**TR010034 – A57 Link Roads**  
**DEADLINE 4 SUBMISSION**  
**But now made in time for DEADLINE 5**  
v2 with material added Friday, 25 February 2022  
Daniel Wimberley, Date Friday, 25 February 2022  
*Unique Reference: 20029775*

**INFORMATION FAILINGS OF HIGHWAYS ENGLAND WITH  
REGARD TO THE A57 LINK ROADS**

HIGHWAYS ENGLAND’S TRAFFIC MODEL THEIR TRANSPORT ASSESSMENT  
REPORT, OTHER INFORMATION FAILINGS AND SUGGESTED ACTIONS FOR THE  
EXA TO TAKE

© OpenStreetMap (and) contributors. CC-BY-SA
 Contains OS data © Crown Copyright and database right

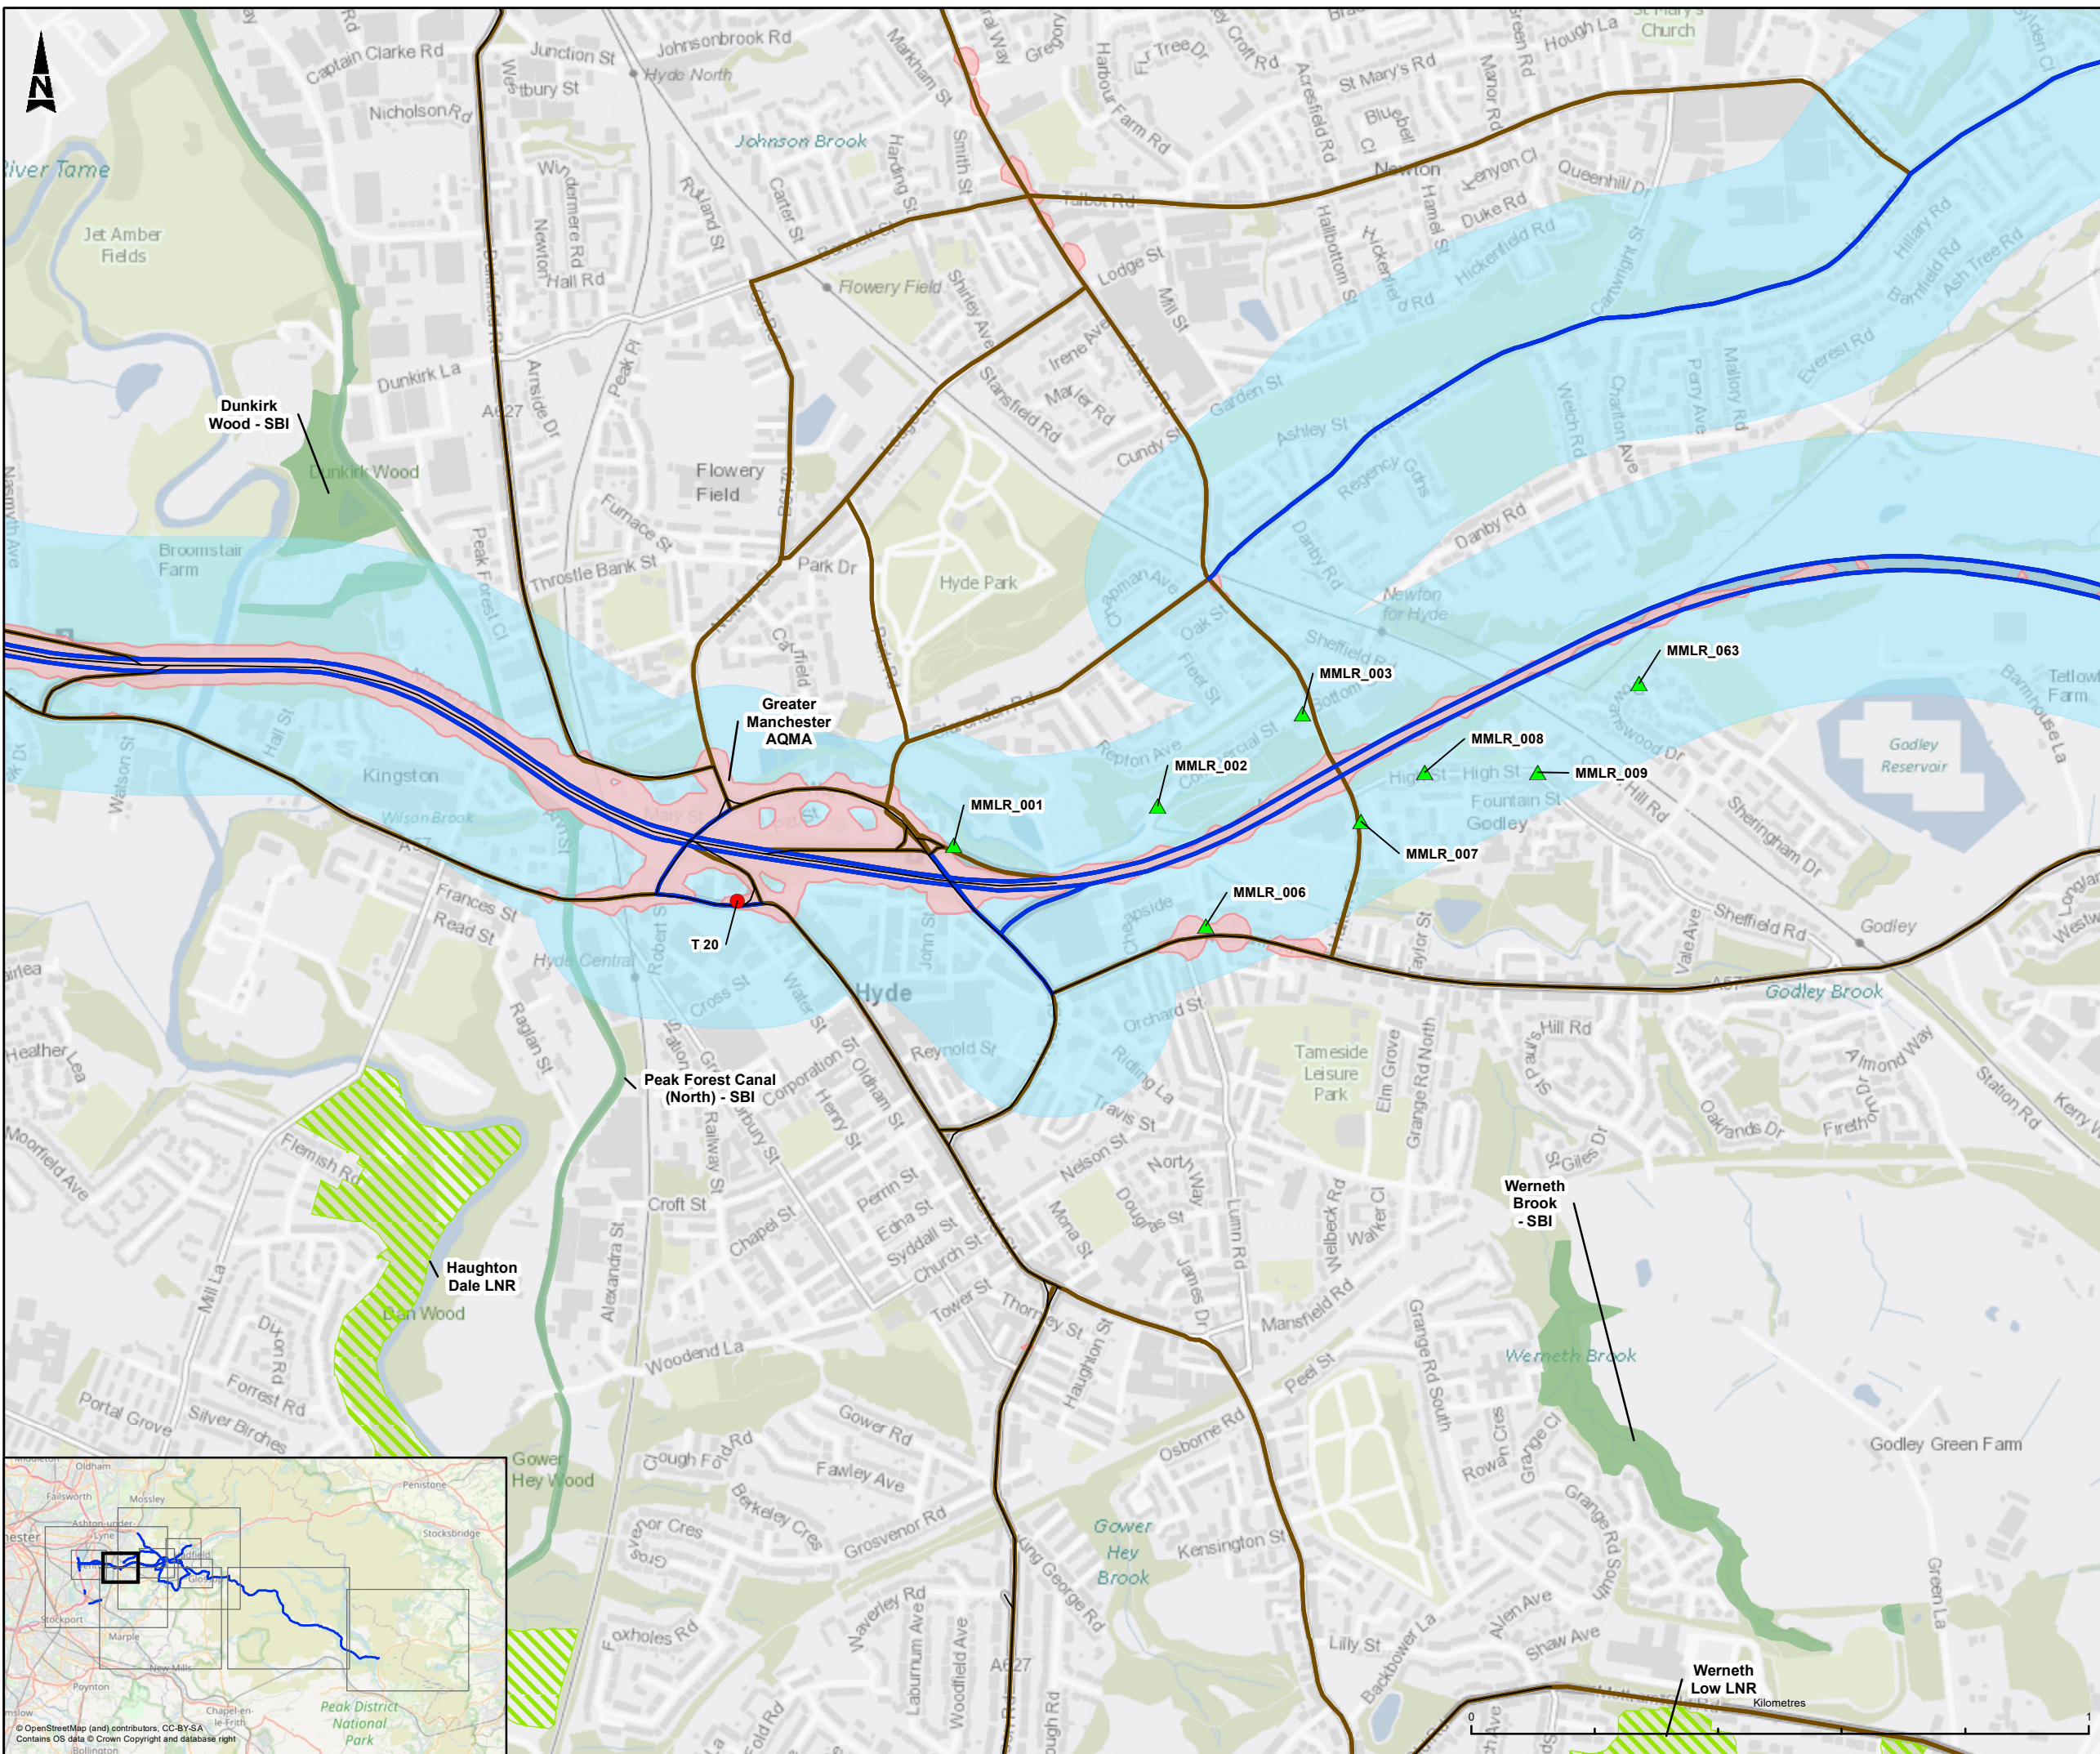
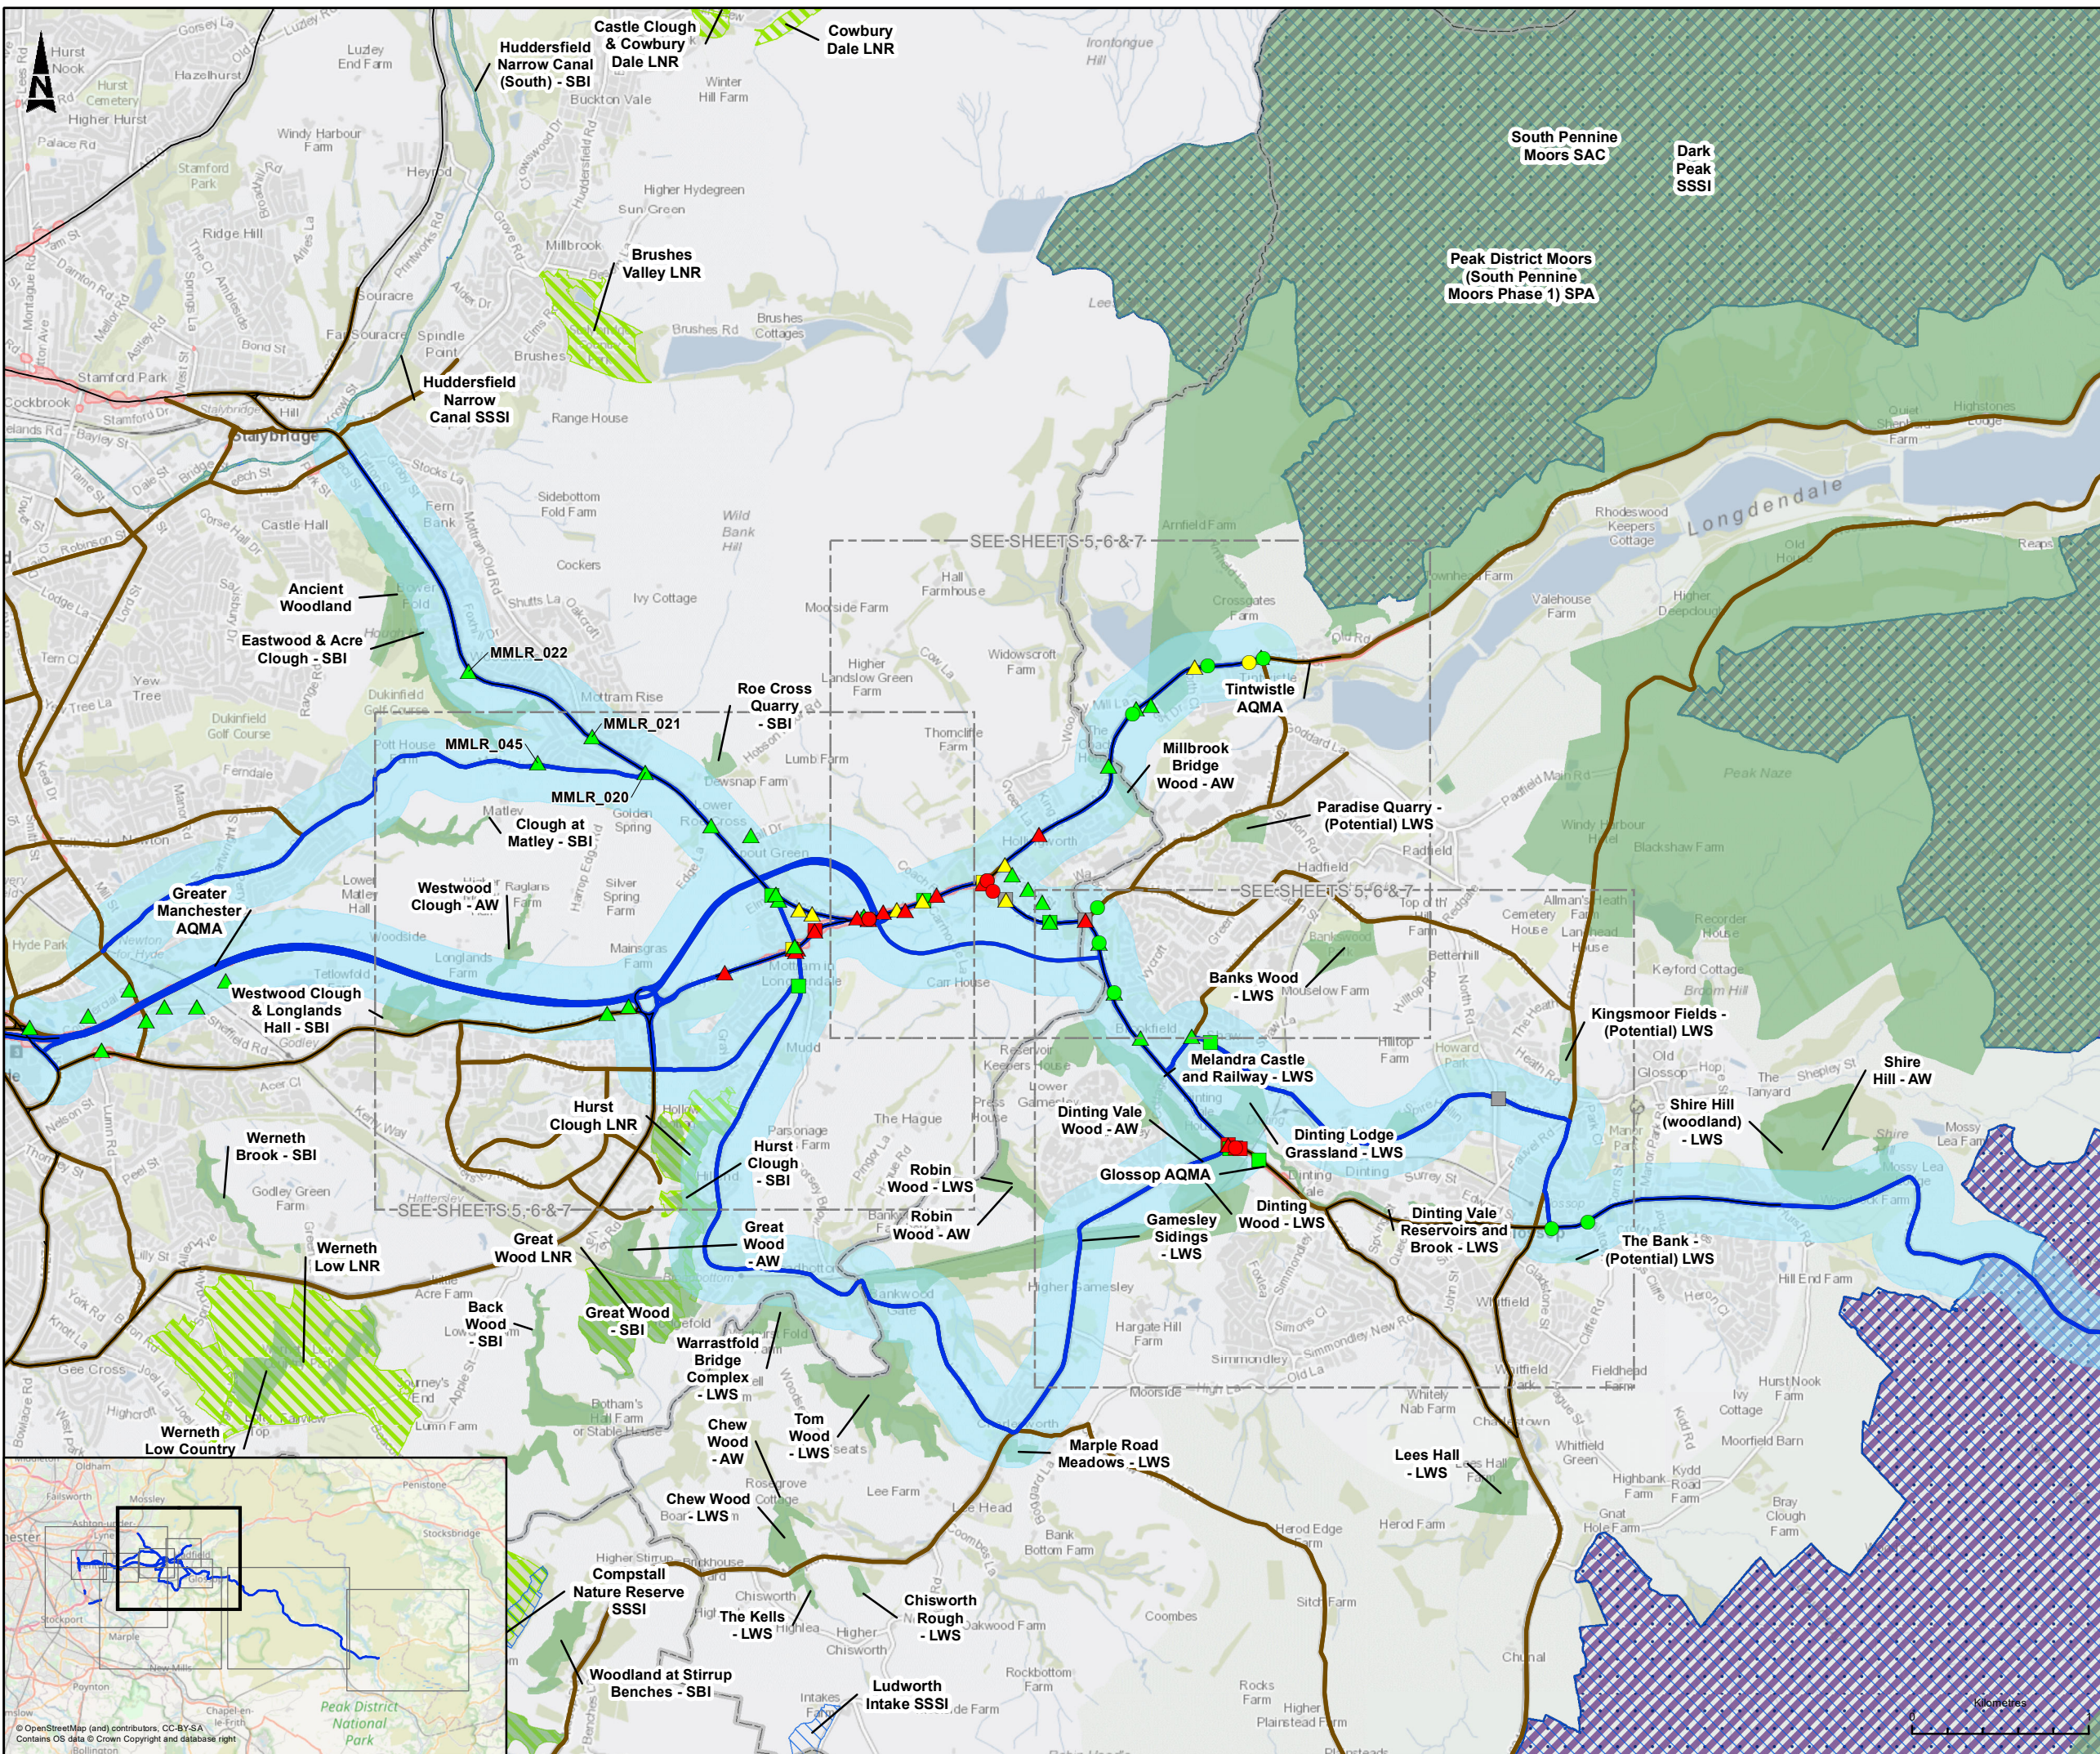
10. The question of **AQMA’s being excluded from assessment** because the increase in flows from DM to DS is “not big enough” made more transparent by slide 9, where they are shown on the map. The relevance of all these key messages is then quite clear. *(slide 9)*

3. As a thought experiment, let us adopt a hypothesis that HE have a great desire NOT to assess AQ issues in the AQMA's of Tintwistle, Dinting Vale and Glossop.

4. For example, in Tintwistle, what matters is the difference between the DS figure and the DM figure **as a number and not as a percentage**. And the other thing that matters is that **that number is less than 1000**.

5. If you apply, say a 10% increase, to a flow of 10,000 you get a numerical increase of 1000. The modelled figure is actually 9699. Et voila – the increase is now 969. *Sorry folks, but the AQMA will not be assessed.*

6. And if you apply, say a 10% increase, to a flow of 11676 (the DfT 2019 estimate for Tintwistle), which is presumably connected to the (accurate) ATC count back on the M67, then you get a numerical increase of 1167. *Oh dear, the AQMA will have to be assessed.*
7. I am NOT saying that DS is derived from DM in this way. But DM and DS figures are connected because the model which gives rise to them stays the same. What matters is the size of the gap, and whether it shrinks when the 2025 DM flow is dramatically altered downwards.
8. The other thing which matters is whether or not we can have faith in the model itself!
